## Community Services Planning Department

**RESPONSE TO COMMENTS MAY 26, 2020**

Reference: Aspen Ranch Construction Plans  
Generally located Northeast of the Intersection of Link Road and Kane Road

I have completed the initial review of the Construction Drawings for Aspen Ranch. The following are items that need to be corrected and/or modified. Once all revisions have been addressed please submit 3 full size drawings. If additional agency comments are received, they will be forwarded to you for review and comment.

CITY FILE NO.:

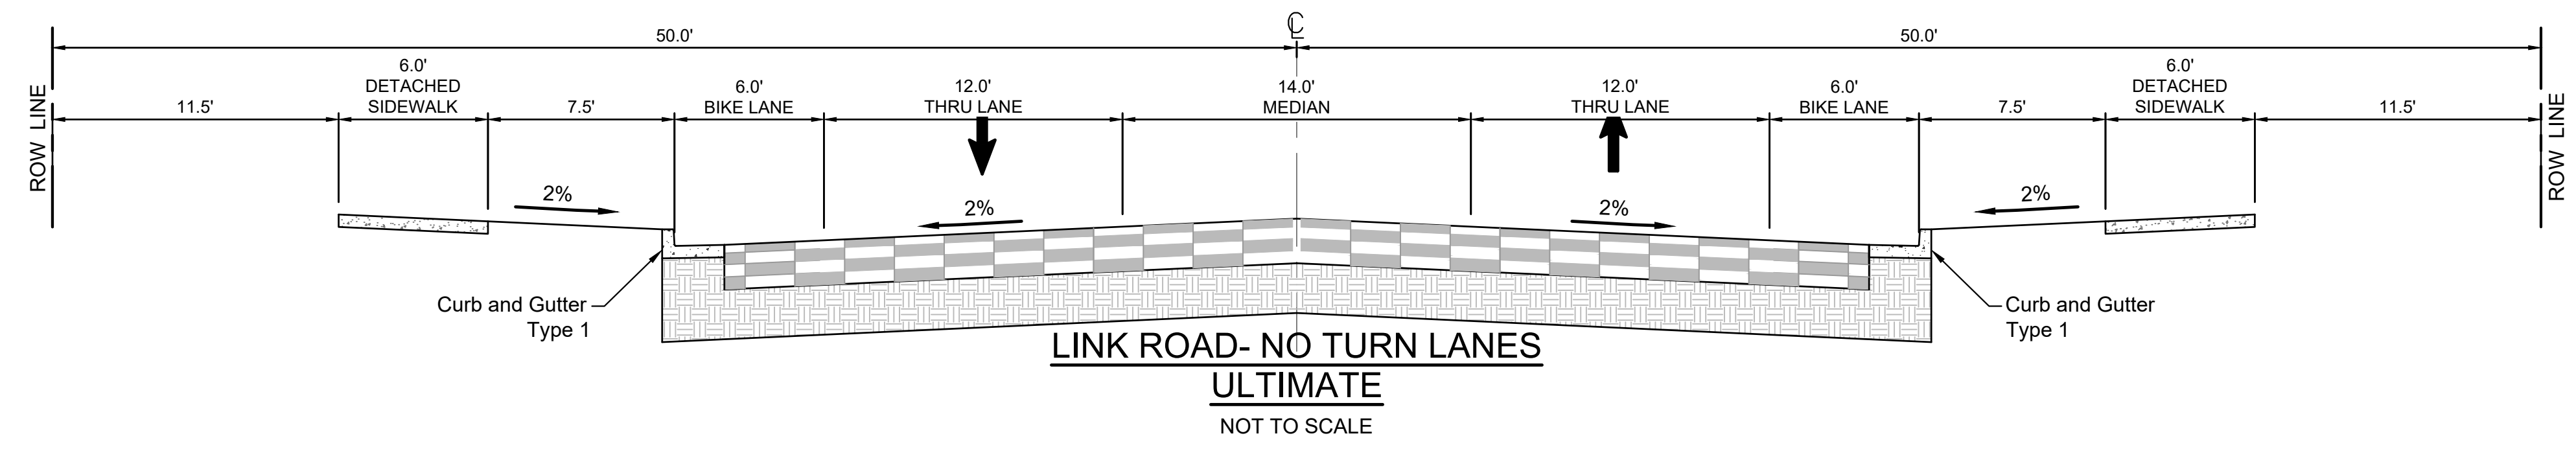
2. Please revise the LINK ROAD – NO TURN LANE INTERIM CONDITION cross section. The City of Fountain Phase 4 project for Link Road will **move** the centerline of Link Road to the Section Line at the intersection of Watchmen Road and between Watchmen Road and Squirrel Creek Road. The Aspen Ranch development is to **move** the centerline of Link Road to the Section Line; please revise the cross section accordingly. Also, this portion of Link Road is to be milled and overlaid. Please email with any questions. **RESPONSE: LINK RD. CROSS SECTION UPDATED ON DT03 AS REQUESTED.**

10. The Kane Road ultimate cross section should match the Link Road ultimate cross section. **RESPONSE: KANE RD. CROSS SECTION UPDATED ON DT03 AS REQUESTED TO MATCH LINK RD. LINE WORK ON PRELIM PLAT ALSO UPDATED.**

11. Revise the Kane Road Interim cross section to have 23' of asphalt from centerline to lip of pan and 6' of asphalt on the other side of centerline. **RESPONSE: KANE RD. CROSS SECTION UPDATED ON DT03 AS REQUESTED TO MATCH LINK RD. LINE WORK ON PRELIM PLAT ALSO UPDATED.**
